## **FIRE RISK MANAGEMENT, INC.**

# **Memo Report**

**Subject: Fire Protection & Life Safety Review of the Proposed Bissell Brothers Brewery**

1 FIRST FLOOR PLAN
A1.01 1/16" = 1'-0"

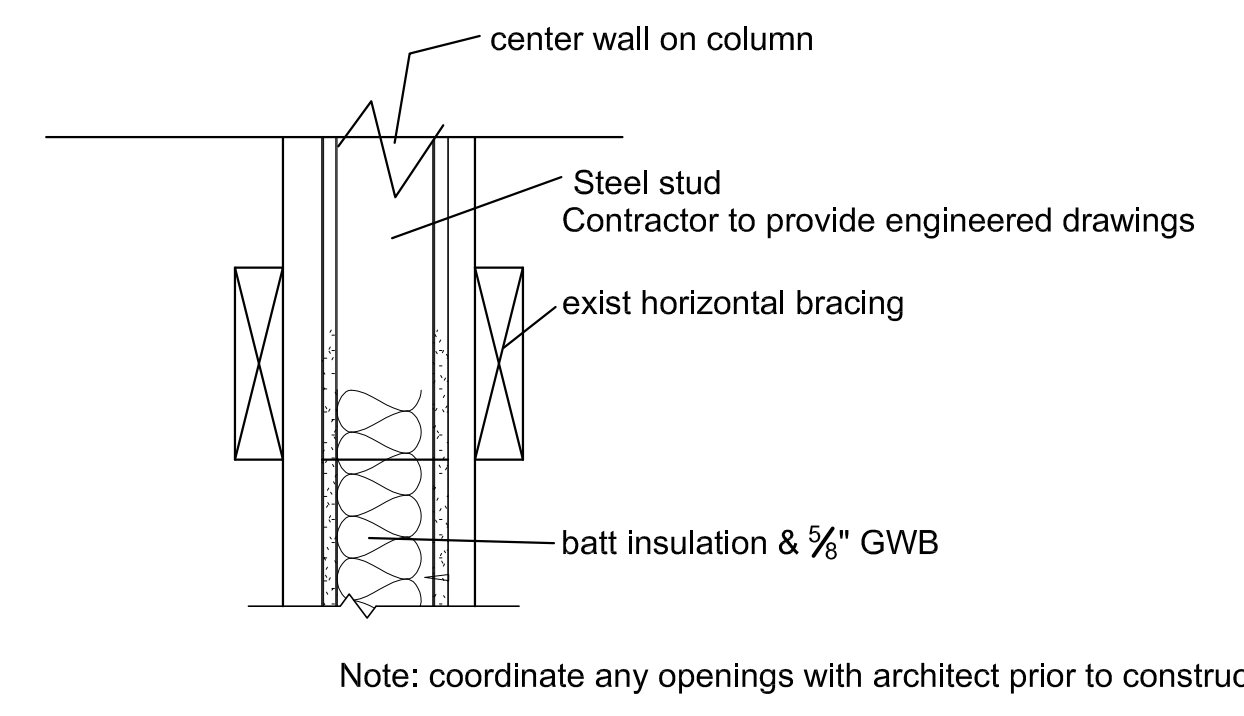
The brewery will consist of a single story that occupies slightly more than 10,000 ft<sup>2</sup> of floor space, but will also include two small mezzanine levels at its southeast and northwest corners. A brewery is classified by the IBC as a low hazard Factory / Industrial occupancy, Group F-2. The design plan for the Bissell Brothers brewery also includes an area that will be designated as a "Tasting Room", which will need to be classified as an Assembly occupancy; Group A-2. As outlined by Table 508 of the IBC, there is no need to provide any fire separation of Group F-2 and A-2 occupancies and it is therefore acceptable for the Tasting Room to be open to the actual brewery portion of this facility.

A small Boiler Room is located at the northeast corner of the brewery. Since the building is protected by an automatic fire sprinkler system, there is no requirement for the Boiler Room to be separated from the rest of the facility by a fire rated barrier.

The small mezzanine area located at the southeast corner of the facility consists of less than 425 ft<sup>2</sup> of floor space. This area is to be used as part of the Tasting Room. The second mezzanine area is located at the northwest corner of the facility and consists of approximately 560 ft<sup>2</sup>, which is to be used as office space that supports the brewery operation. Each mezzanine is open to the rest of the facility and is provided with a single staircase that leads to the main floor level.

Based on a review of the proposed facility design, all areas of the brewery are provided with adequate means of egress. The only “caution” that needs to be included with this review is the fact that the occupant load calculations included on the plans are based on a portion of the Tasting Room being provided with installed tables and chairs; hence using an occupant load factor of 15 ft<sup>2</sup>/person in lieu of 7 ft<sup>2</sup>/person for areas that are to be “open” floor space. The Tasting Room area, which includes its associated mezzanine level, is provided with access to two (2) exits as required by code. Each exit consists of a 3-foot door, which typically provides approximately 34 inches of clear width. As such, each exit has the capacity to accommodate up to 170 persons; for a total capacity of 340 persons. It is also required that 50% of the remaining occupant load for the rest of the brewery areas be accommodated by these exits. Based on the current plan/occupant calculations; the exit capacity from the south side of this facility is only slightly higher than the estimated occupant load that must be accommodated; FRM calculated an occupant load of 330 persons to be accommodated by these exits. Any reduction in the actual configuration for the Tasting Room that is dedicated to the installation of tables and chairs could result in the estimated occupant load exceeding the exit capacity available on this side of the facility. The remainder of the brewery facility will have access to two separate exits that will have more than sufficient capacity to accommodate the estimated occupant loads from these areas.

Each of the two mezzanine levels is provided with adequate means of egress; which consists of a single stairway that provides access to the main floor level. All exit travel distance requirements/restrictions, including both common path of travel and total distance to an exit, are compliant from all areas, including the mezzanine area that is part of the Tasting Room.

Based on a review of the plans provided by Archetype Architects, the proposed design for the new Bissell Brothers brewery appears to be fully compliant with all applicable codes. Based on the configuration for this facility, coupled with the lack of any significant fire hazards that exist, the proposed layout easily provides sufficient life safety for all occupants. However, consideration should be given to providing additional exit capacity from the south (Tasting Room) side of the facility to allow greater flexibility in the arrangement used for the Tasting Room; specifically to alleviate any need to dedicate a specified amount of floor space within this area that must be provided with tables and chairs. If one of the two exits was provided with a set of double doors, no restrictions would exist on how this area would need to be configured.
